MU GROUP CONSULTING

TECHNICAL NOTE

**State Significant Development at 884-928
Mamre Road, Kemps Creek**

Ref: P21_19_APP_Mamre_WAD_DD

**Annexure 3 – Proposed LILO with TfNSW Ultimate Design Overlay  
2021\_19\_SD\_0001\_SK00018 Issue A**

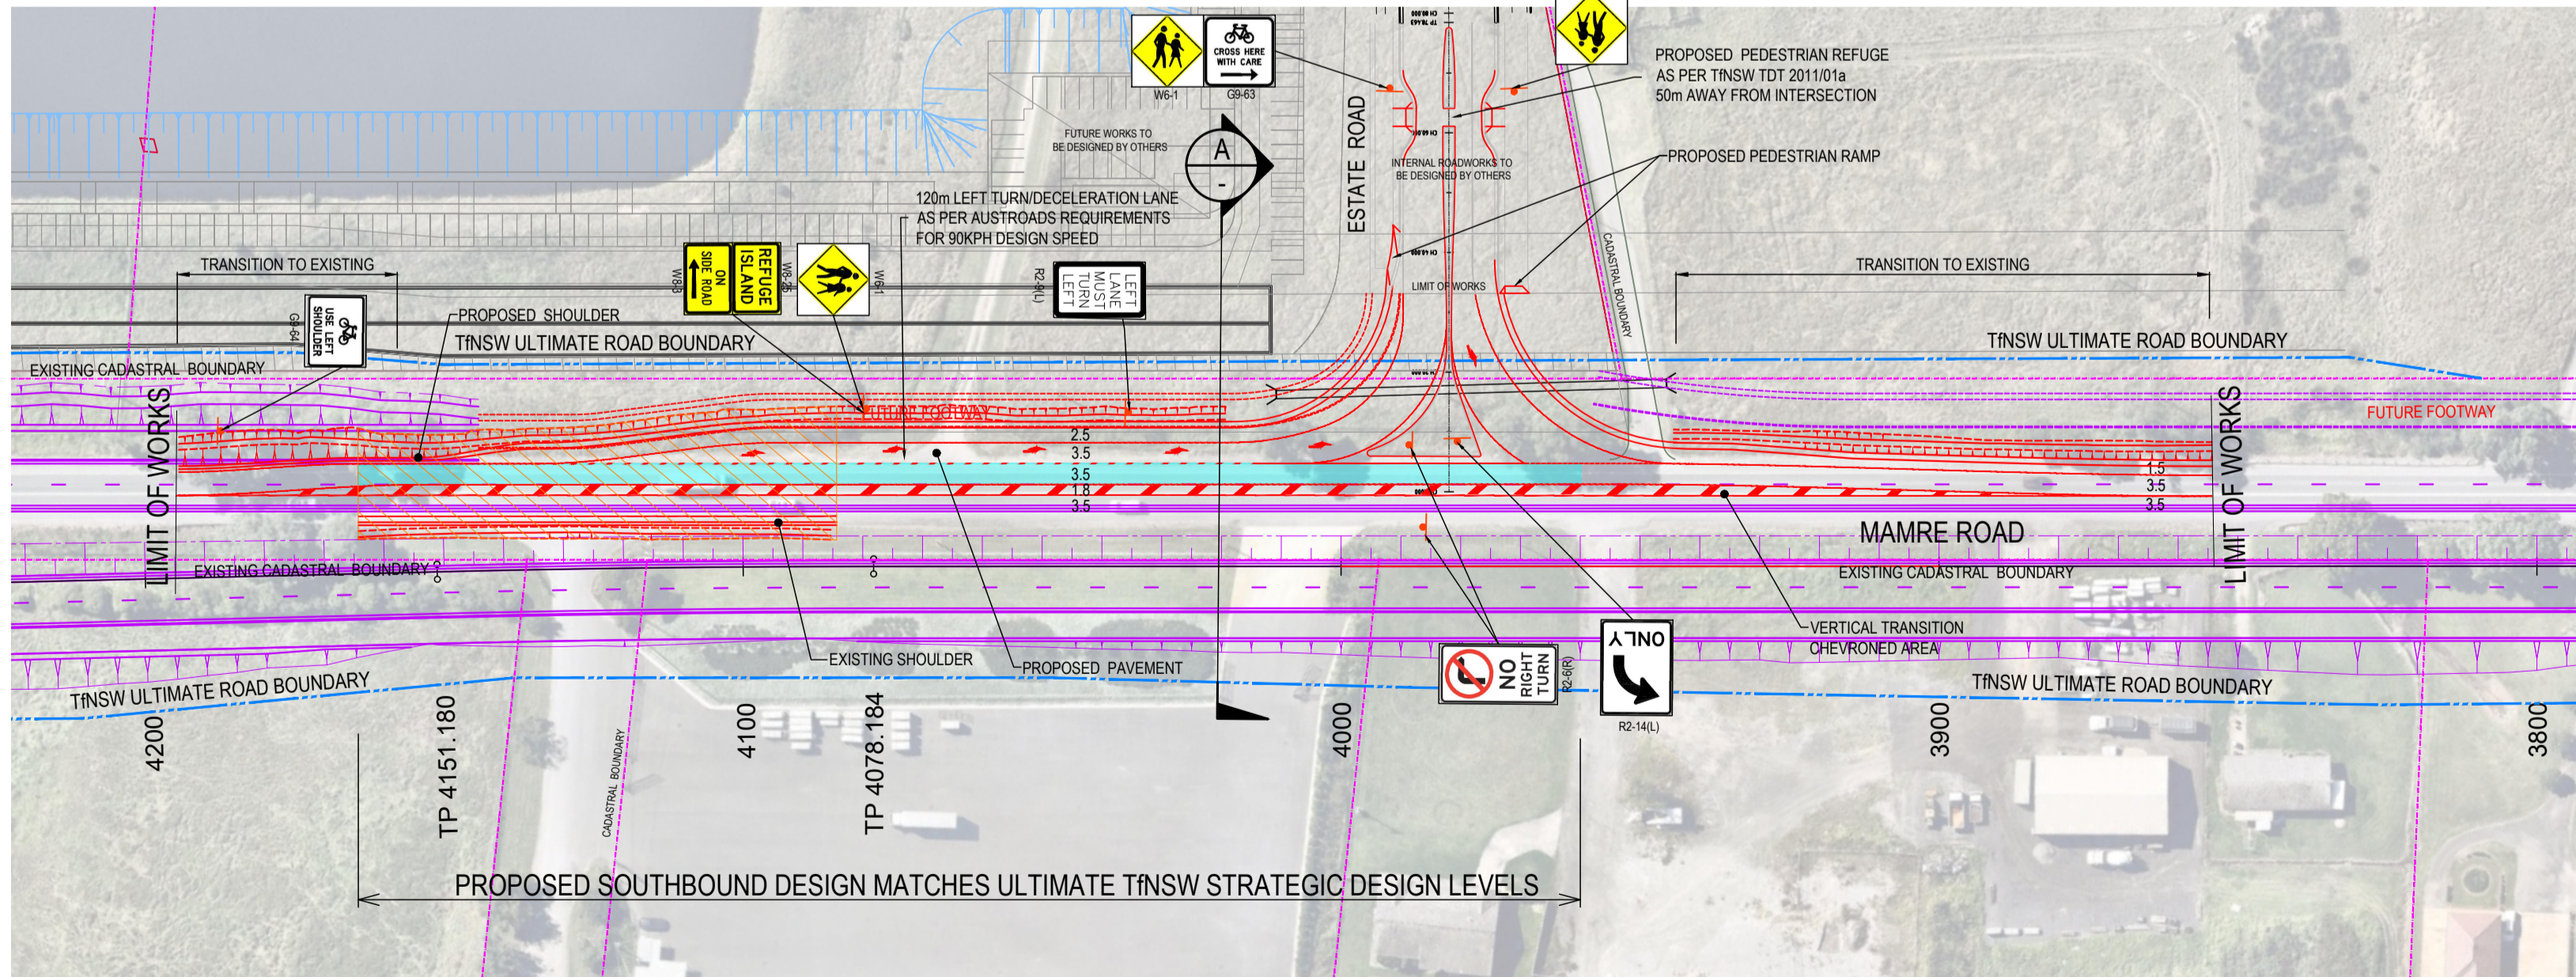
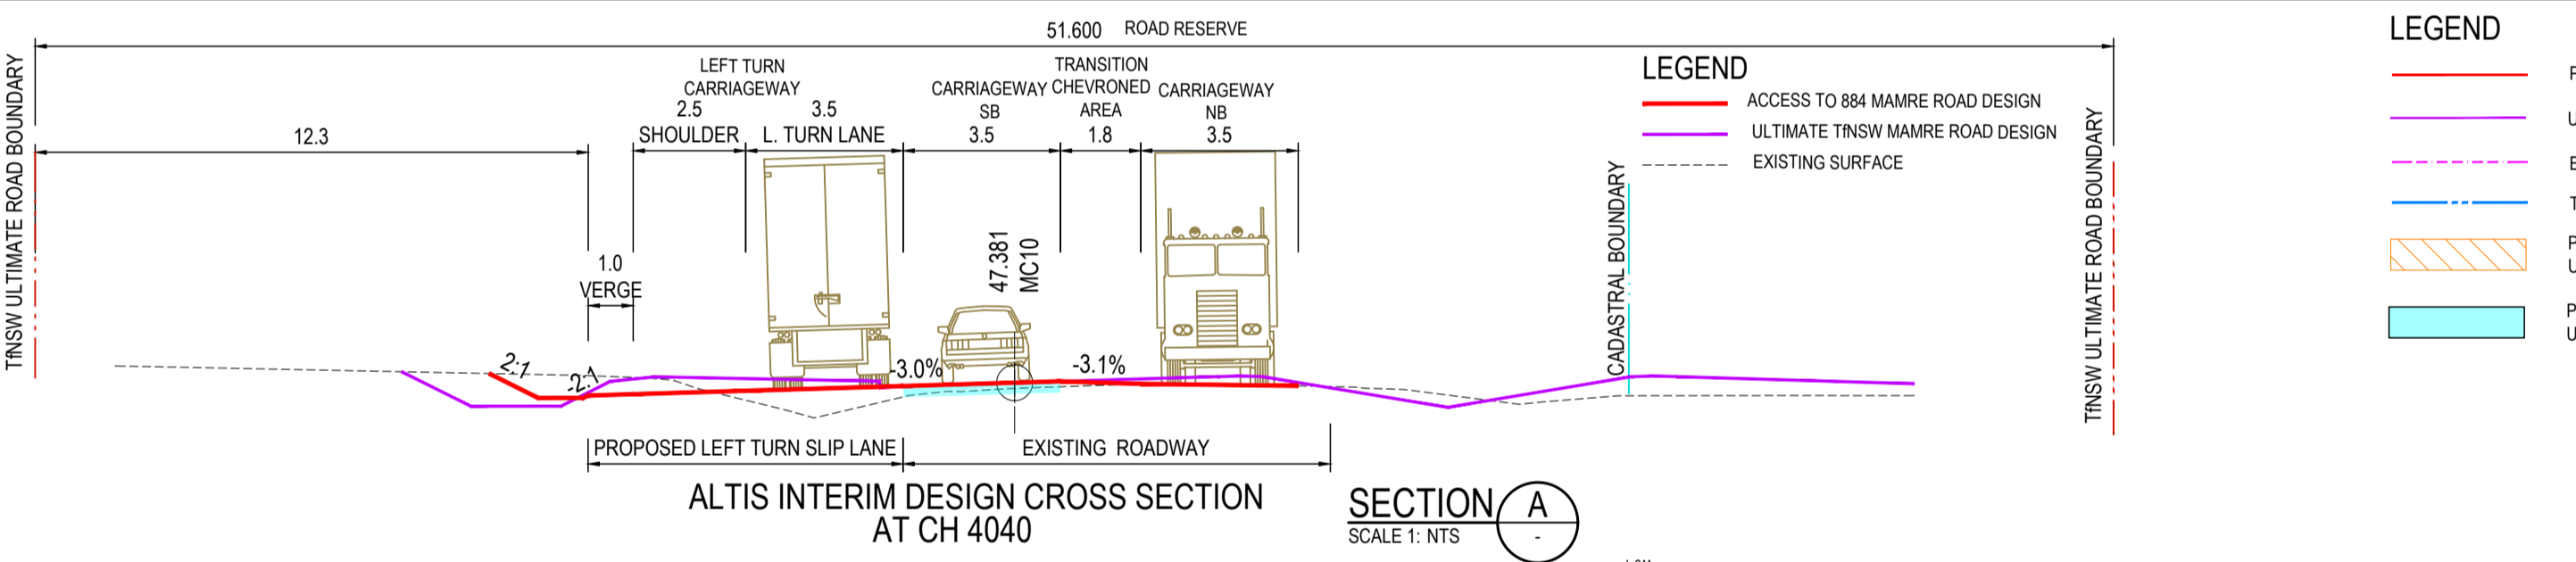
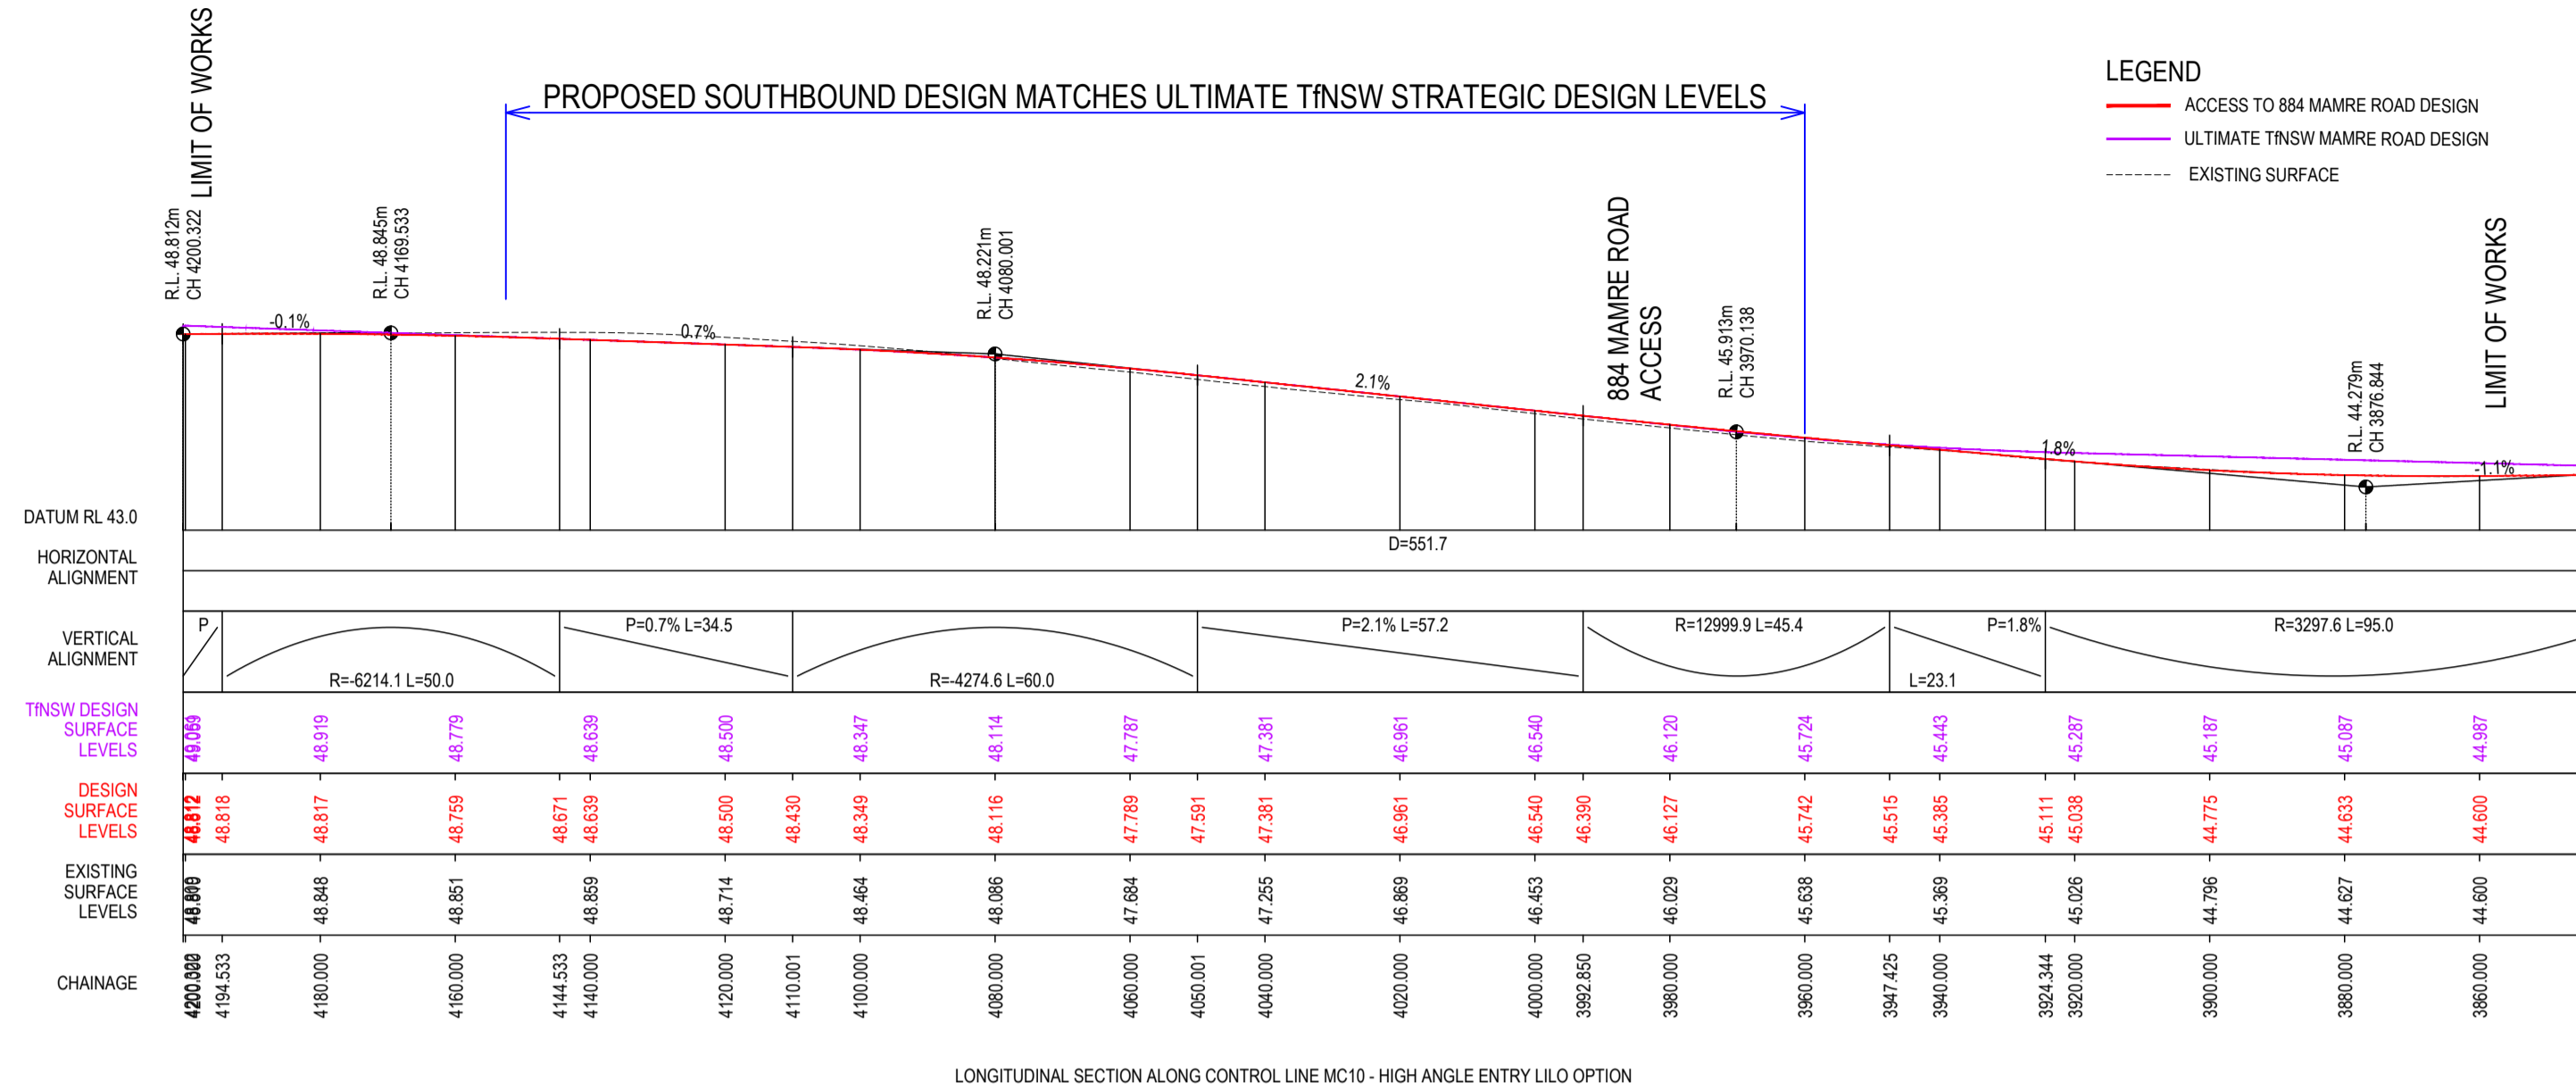
8. Design showing location of LILO with the ultimate Mamre Road upgrade alignment

The strategic design has been overlaid on the TfNSW Mamre Road "Ultimate" design. Refer to Drawing No. 2021_19_SK_0007. The plans show that the LILO is constructed outside the ultimate Mamre Road design footprint and includes a shared path that can tie up with the ultimate design following the merger.
